DOC17/287430-04

**Altis Warehouse and Logistics Hub (SSD 7173) – MOD 3**

I am writing in relation to your request for comments on the application by Altis Property Partners Pty Ltd (the Proponent) to modify the existing consent for a warehouse and logistics hub at 585-649 Mamre Road, Orchard Hills, which was received by the Environment Protection Authority (EPA) on 27 July 2018.

Figure 5 | Approved and Proposed Drainage Works

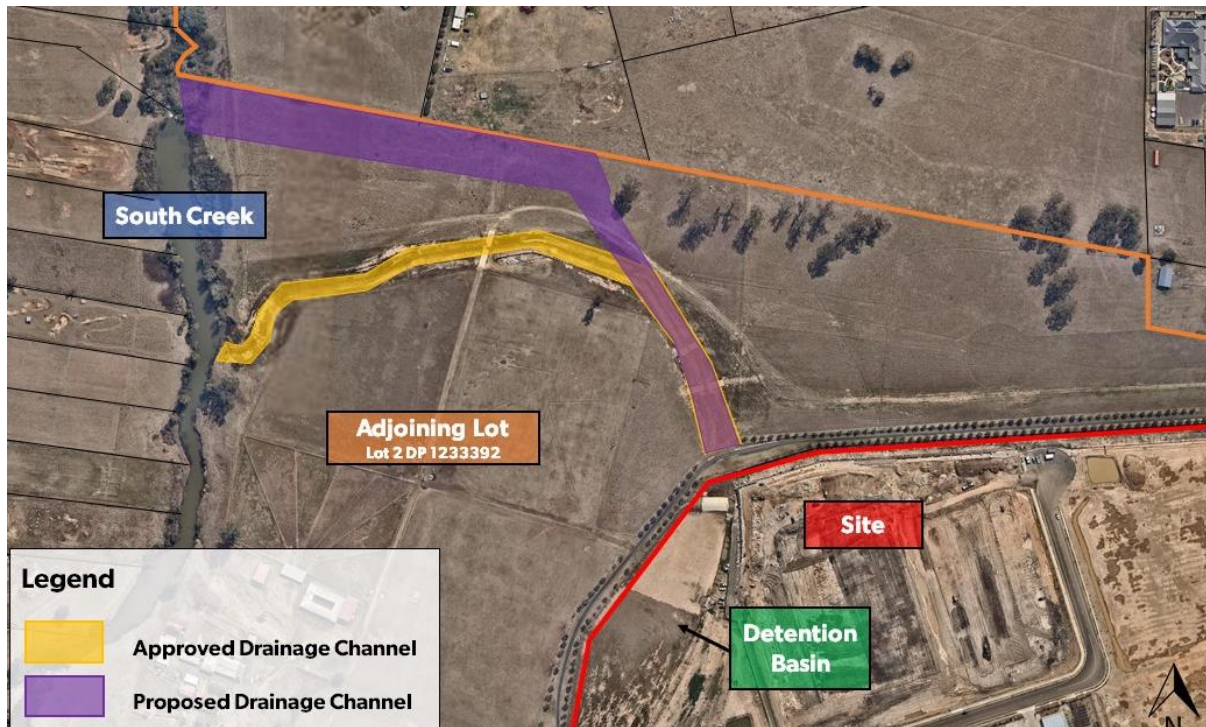
The EPA notes that Proponent has not identified how the proposed channel realignment, which is within the South Creek catchment, addresses the sustainability directions within the *Western City District Plan* (Greater Sydney Commissions, March 2018). For example, planning priorities W12 and W13 which relate specifically to South Creek.

- specify the proposed water quality targets for the proposed channel realignment, consistent with the NSW Water Quality Objectives. Generic percentage load reduction targets are not supported by the EPA as these do not reflect contemporary integrated water cycle management and are unlikely to improve the health of South Creek; and
- clarify how it will meet its waste obligations in relation to the proposed importation of fill, including by updating any fill importation protocol or similar.
